**KIRKLEES METROPOLITAN COUNCIL
INVESTMENT & REGENERATION SERVICE**

**DELEGATED DECISION FOR DISCHARGE OF CONDITION A.4 -
NOTIFICATION OF A PROPOSED ENLARGEMENT TO DWELLINGHOUSE**

Reference no.	2025/HH/91633/W
Site Address	349, Blackmoorfoot Road, Crosland Moor, Huddersfield, HD4 5QU
Description	The proposal is for erection of single storey rear extension. The extension projects 6m beyond the rear wall of the original dwellinghouse. The maximum height of the extension is 3.58m, the height of the eaves of the extension is 2.4m
Recommending Officer	Molly Storer

DECISION - REFUSED

Ground Floor Layout 1.50

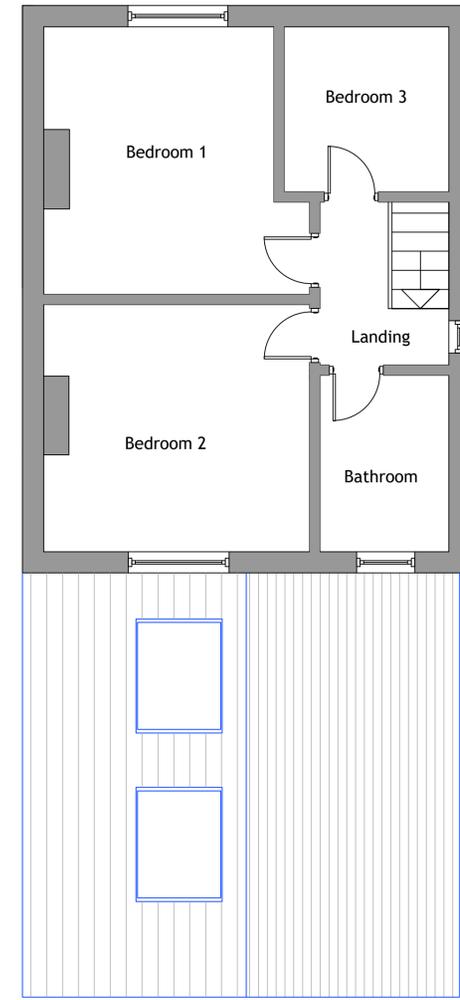
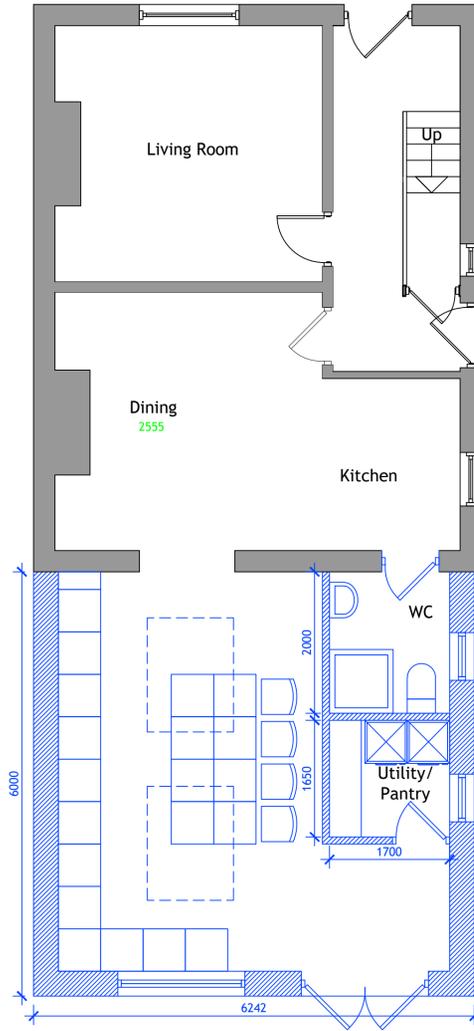
Aerial imagery from 2021 shows two projections from the rear elevation one being a conservatory which is proposed to be demolished as part of the development. This element is not considered to be an original part of the dwellinghouse as was added later than 1965. However, the other element is considered to be an original part of the dwelling house which has a 1.3m projection and appears to serve as a store. The proposed extension projects from the rear of the original dwellinghouse by 6 metres along part of the rear elevation and 4.7 metres beyond an existing part rearward projection which is proposed to be demolished. The Council's historical imagery dated 1922 does

not show the dwellinghouse to have been built. However, imagery dated 1933, 1955, 1956, 1968 & 1968 consistently indicate the existing rearward projection was original to the dwellinghouse.

To further support this evidence is that the adjoined property to the application site, No.351, also has a mirrored rearward projection indicating No.349 and No.351 were both constructed as a matching pair of semi-detached properties. This is also a pattern seen along this part and side of Blackmoorfoot Road.

Having regard to the Government's householder guide to permitted development rights (2019) and sub-paragraph A.1(j), Class A, Part 1 of Schedule 2 of the Town and Country Planning (General Permitted Development) (England) Order 2015 (as amended) development is not permitted under Class A where the proposed extension extends beyond a side elevation of the original dwellinghouse and has a width greater than half the width of the original dwellinghouse. In this case the submitted plans indicate the proposed extension extends along the whole rear elevation also projecting from the side of the original rearward projection of the property and is therefore contrary to paragraph (j) of Class A and as such cannot benefit from a permitted development.

The proposed enlargement does not benefit from a general planning permission under Article 3(1) and Class A, Part 1 of Schedule 2 of the Town and Country Planning (General Permitted Development) (England) Order 2015 as the rear projection extends beyond a wall forming a side wall of the original dwellinghouse and has a width greater than half the width of the original dwellinghouse contrary to sub-paragraph A.1(j) of Class A.
